Huntlee New Town Residential Subdivision Stage 1 (MP 10_0137 MOD 14) – Review of Modification

Huntlee New Town Residential Subdivision Stage 1 MOD 14

BCD's detailed comments

Northrop 1% AEP Flood Depth and Extent

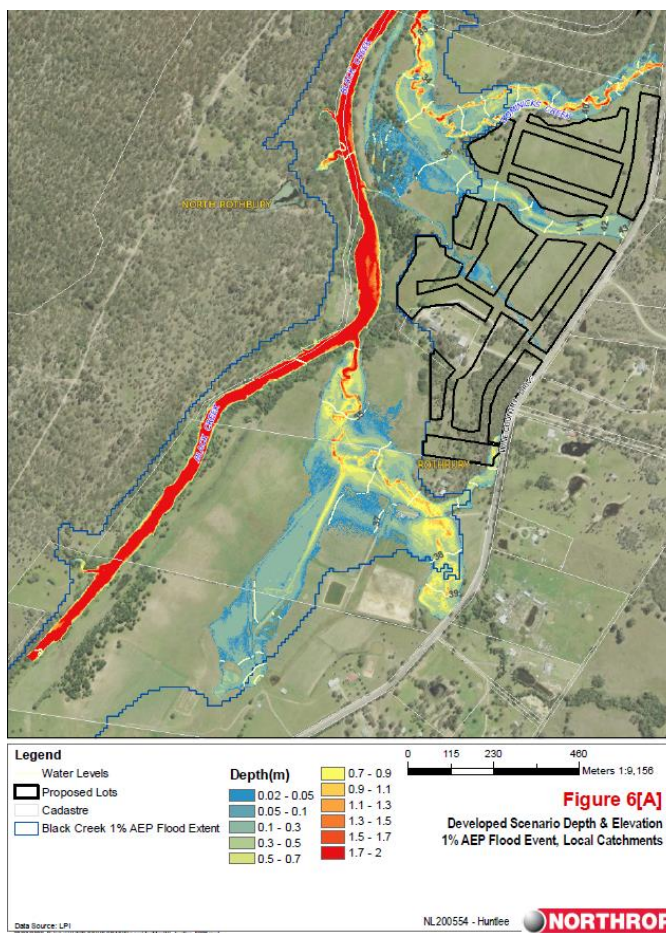
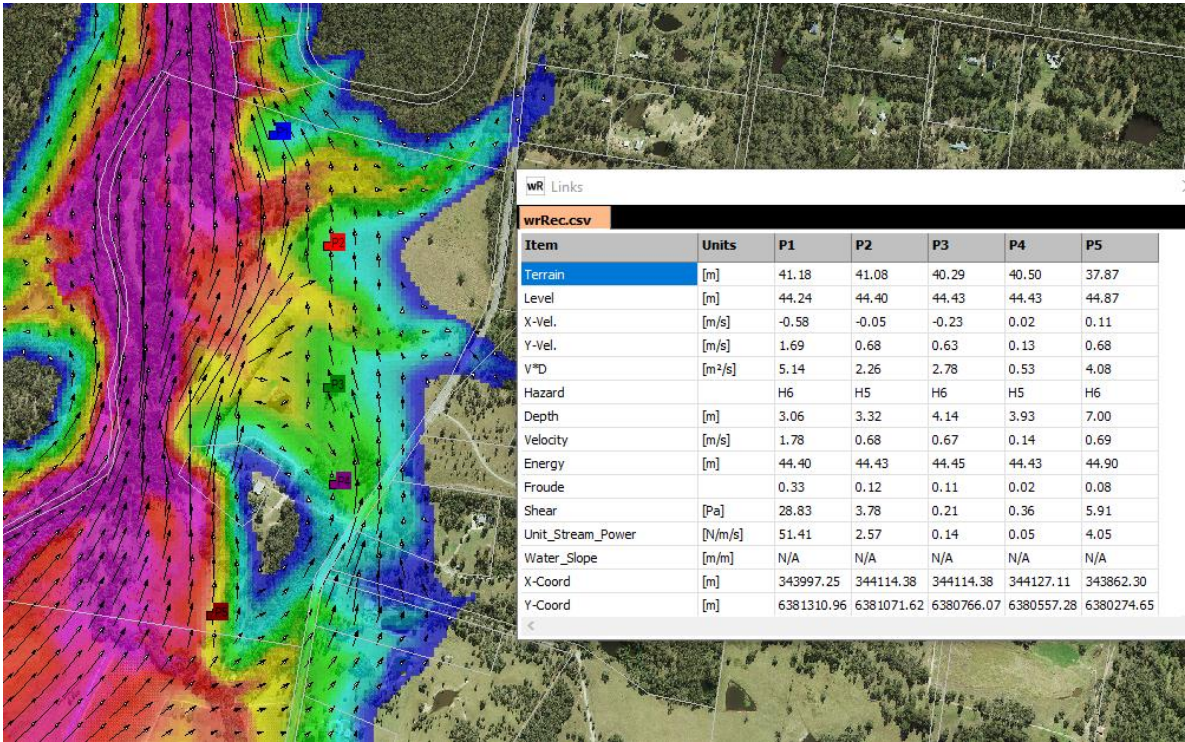
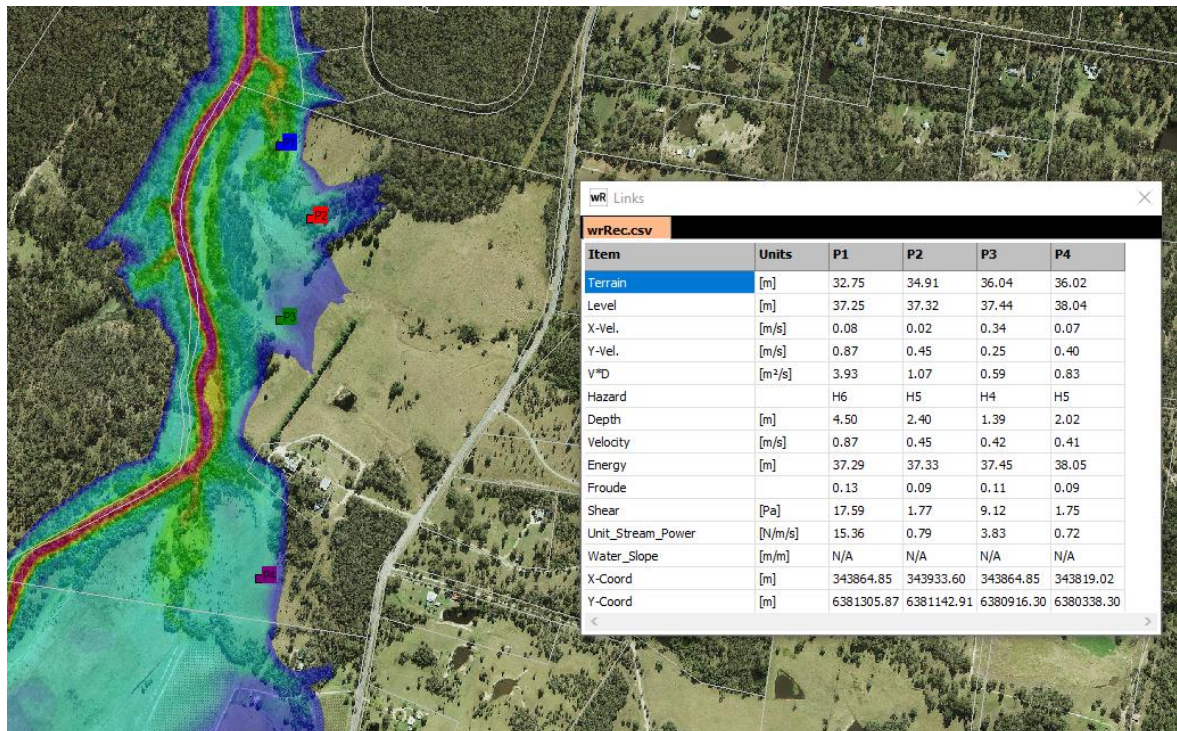
It appears that through the use of incorrect data for losses, hydraulic roughness and modelling processes that the Northrop study underestimates flood extents and risks at the site.

The proposed modification would transfer riparian corridors from public to private ownership and place large lots within the probable maximum flood (PMF) extent established by the Black Creek flood study. These lots would need to be evacuated in floods larger than the 1% Annual Exceedance Probability (AEP) and it is likely that a flood warning system would need to be established to ensure this can safely occur.

Recommendation 6 from BCD's original letter should be adequately addressed. In addition, a copy of the data obtained from the ARR 2019 data hub should also be provided with the revised assessment.

Recommendation 8 from BCD's original letter should be adequately addressed.

Figure 2 – Hydrograph of peak from 1% AEP 36-hour event

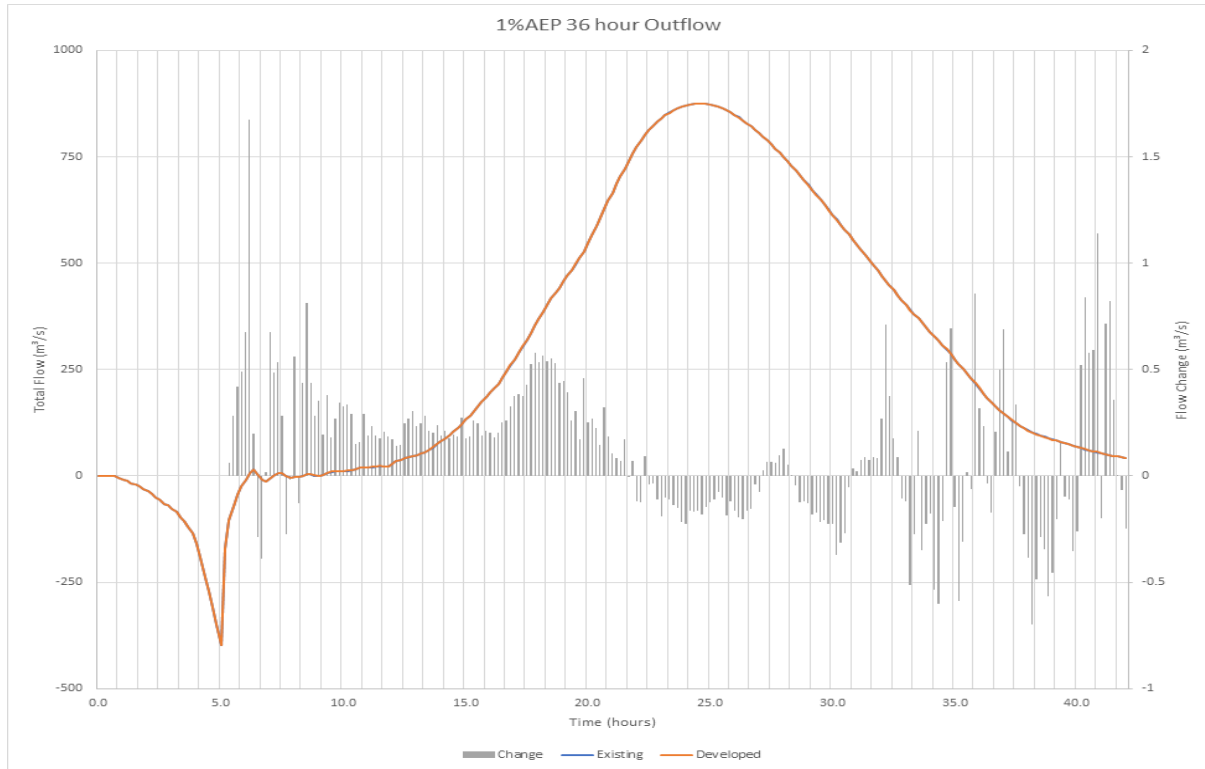
The proponent has not justified the removal of on-site detention from its Stormwater Management Strategy and the issues raised under point 7 of BCD's original letter have not been addressed. As outlined in point 1, it appears that flood flows have been underestimated and incorrect roughness values have been adopted, therefore the hydrographs provided in support of the proposed modification are not considered to accurately represent stormwater flows.

Recommendation 7 from BCD's original letter should be adequately addressed.
